Oxfordshire County Council's response to Cherwell District Council's consultation on amended application for Phase One North West Bicester Eco-town (No: 10/01780/HYBRID)

1. Based on the amended information in the application, it is recommended that the County Council should submit an **objection** to the proposals to Cherwell District Council (CDC).

Daniel Round and Linda Currie
26 May 2011

Title
**EXEMPLAR LAYOUT
SHEET 2 OF 2
DRAWING 3-1**

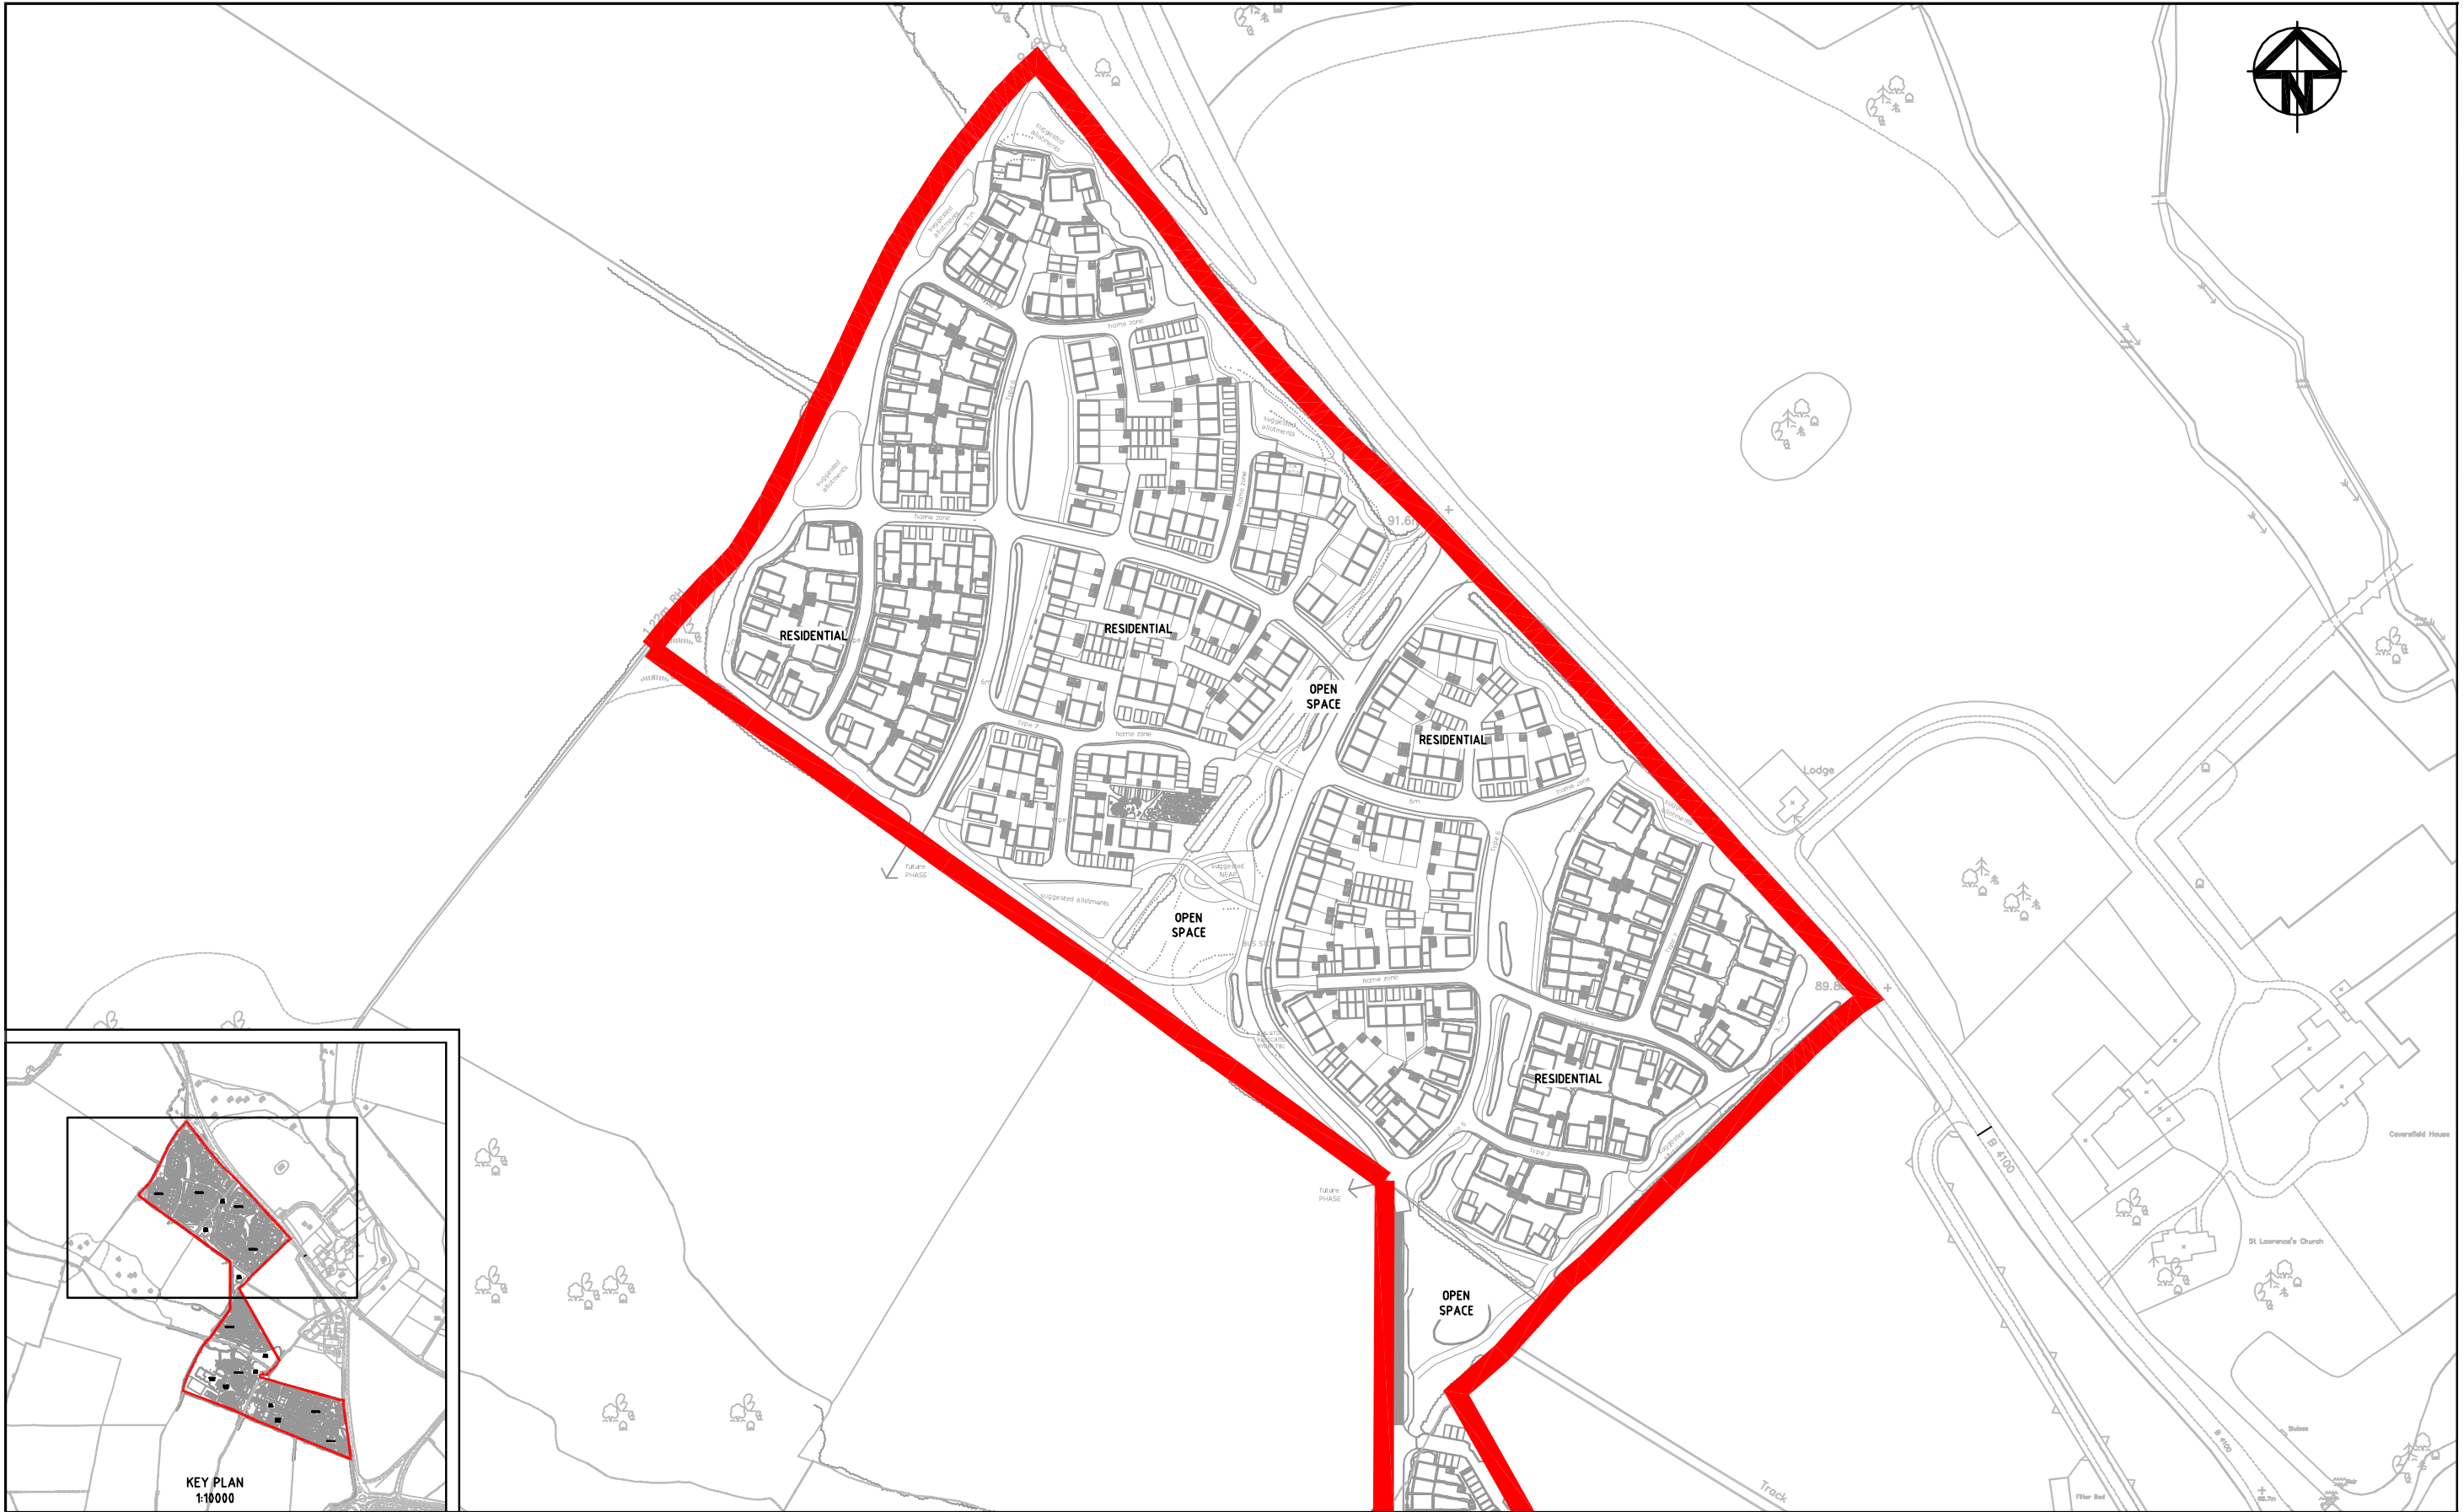
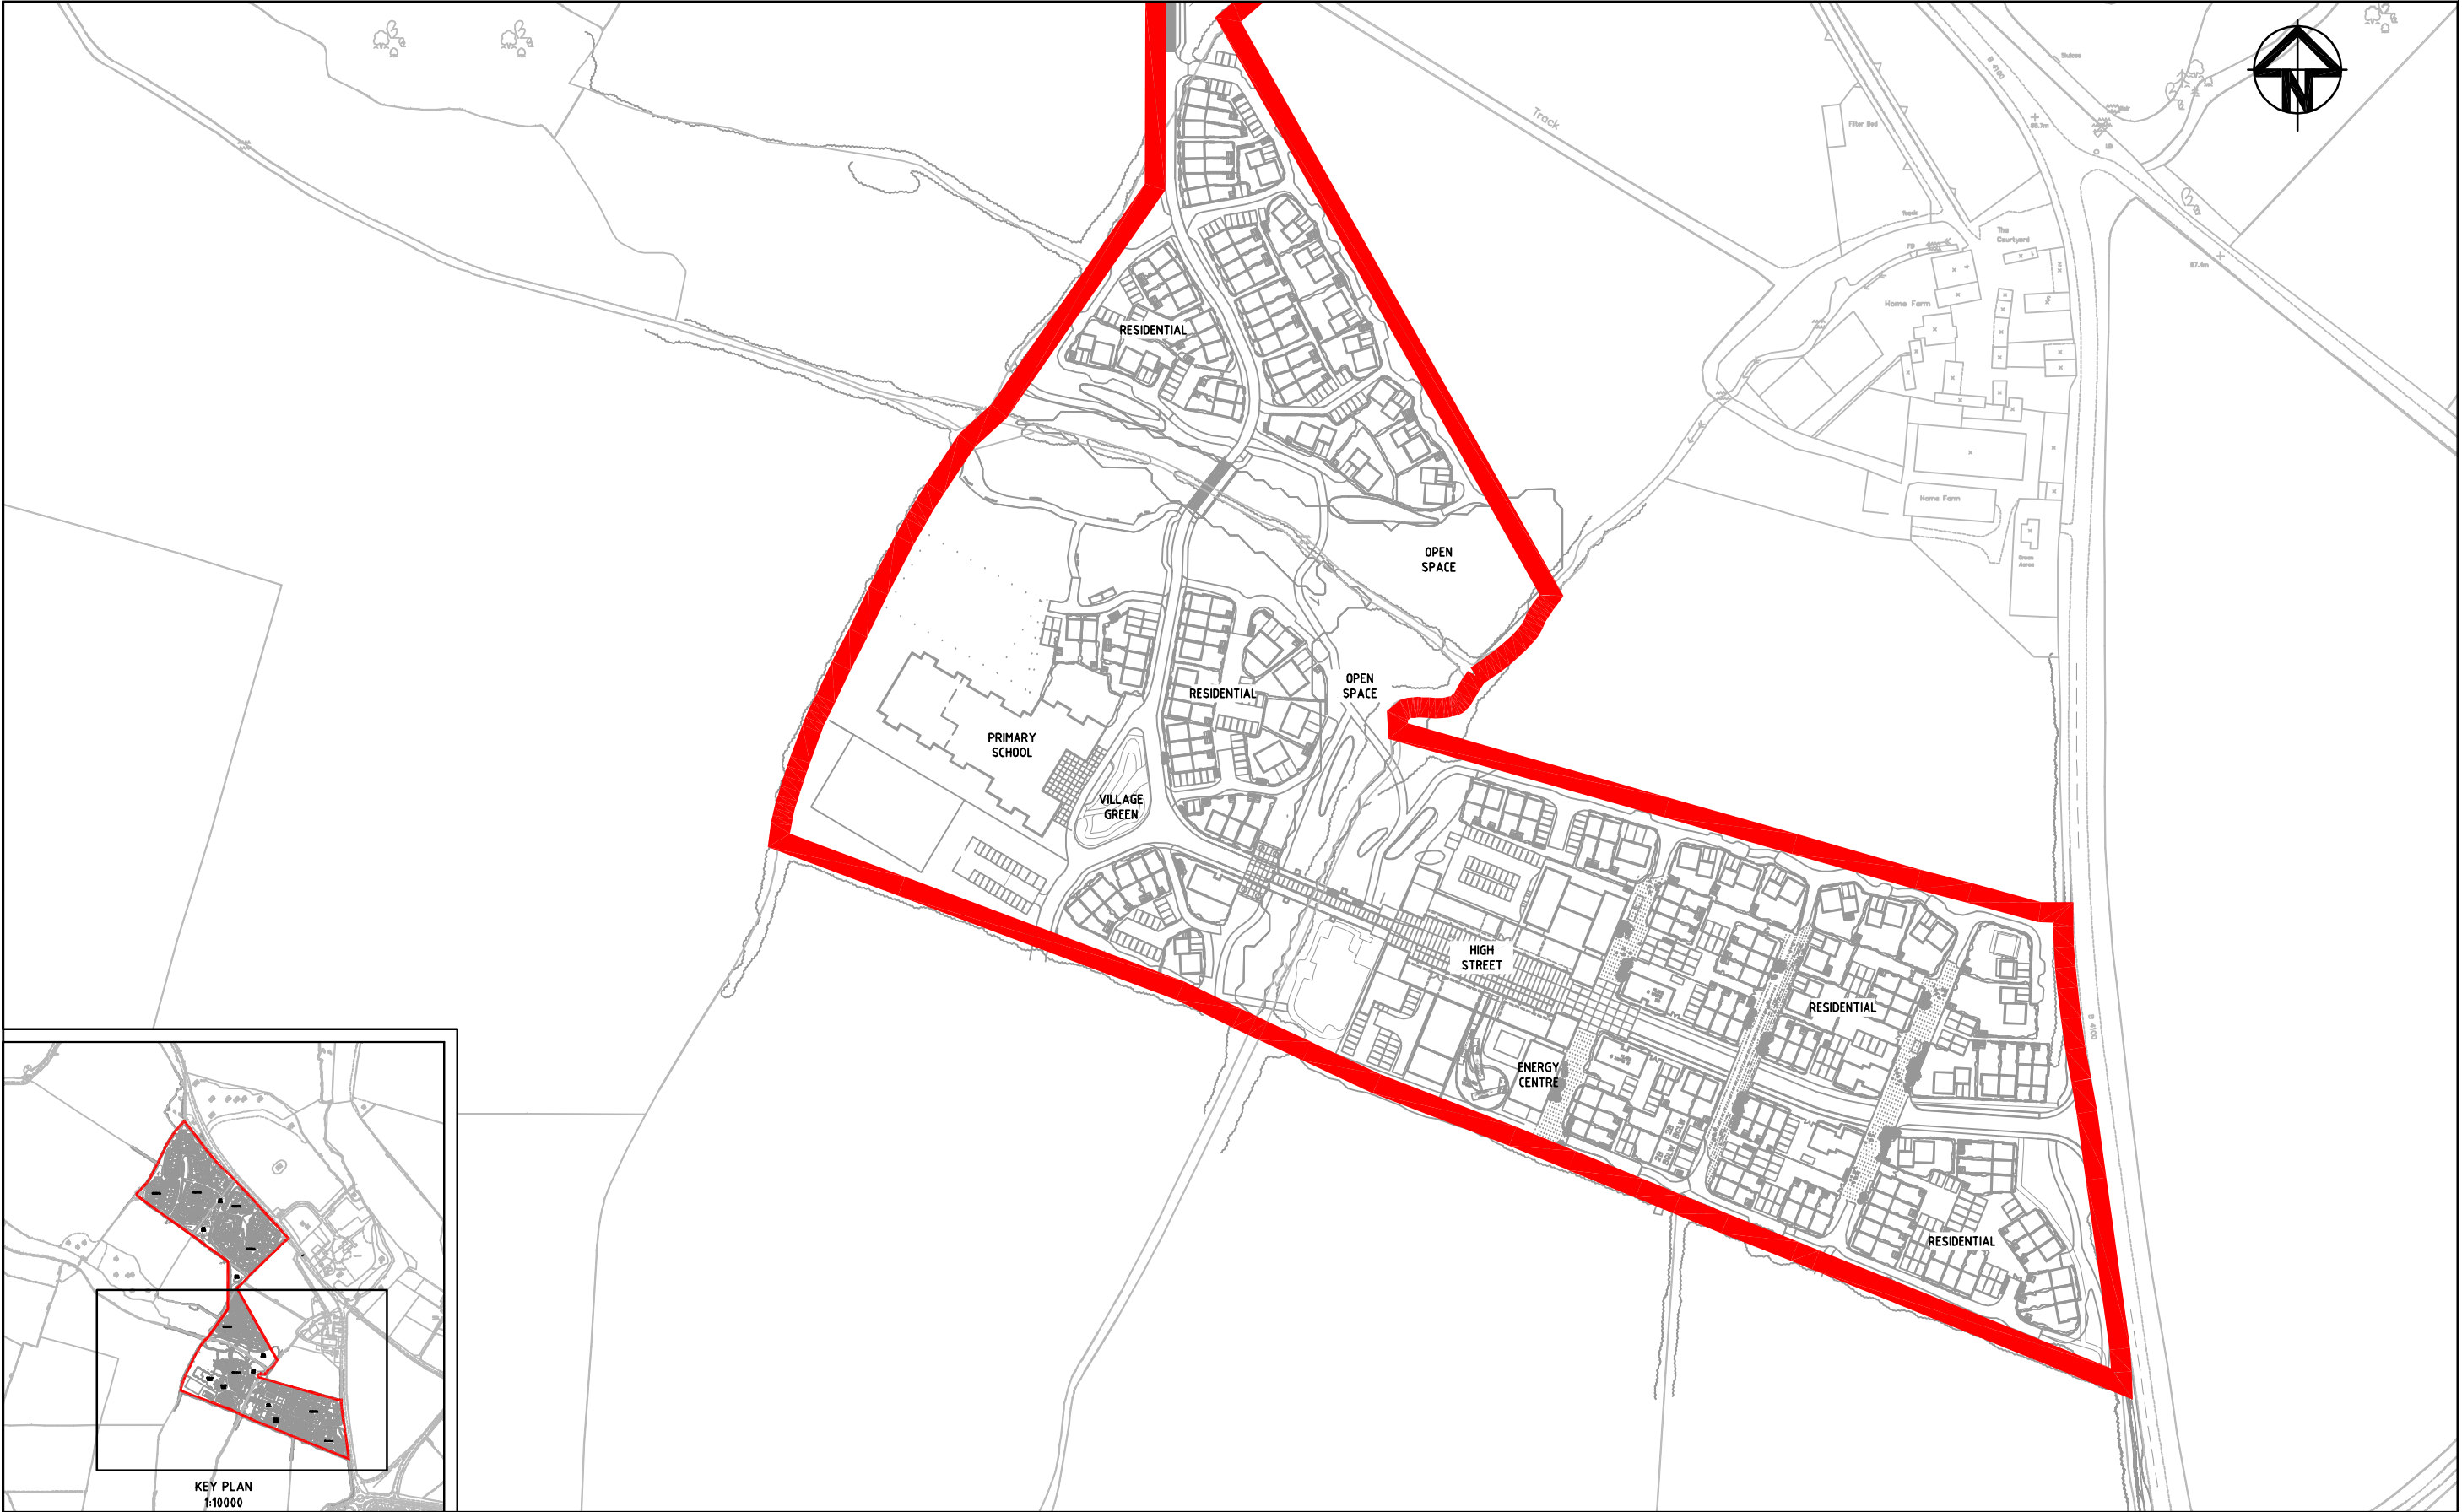
18. The amended application provides land for a school but further detailed information is still needed to fix the size of the site, its shape and location. This is all critical in order to assess the acceptability of the proposal.

19. Officers have been requesting this information for a number of months but have yet to receive it from the applicant. In the last week, the applicant has submitted an earthworks plan, which would see a significant change in levels in and around the proposed school site. Officers' initial assessment is that this will make the school site unacceptable. As a consequence our objection on this issue should be sustained.

20. The application shows land for phase 2 of the school to the west of phase 1; we have previously stated our expectation for the extension to be to the south and this continues to be the case.

24. **Recommendation: OBJECT**, unless the proposed site and land proposed for its extension are demonstrated to be acceptable and the S106 contributes appropriate funding towards the provision of the new 1FE primary school building with 2FE core facilities plus the costs of any temporary education arrangements, including transport required in the short term.
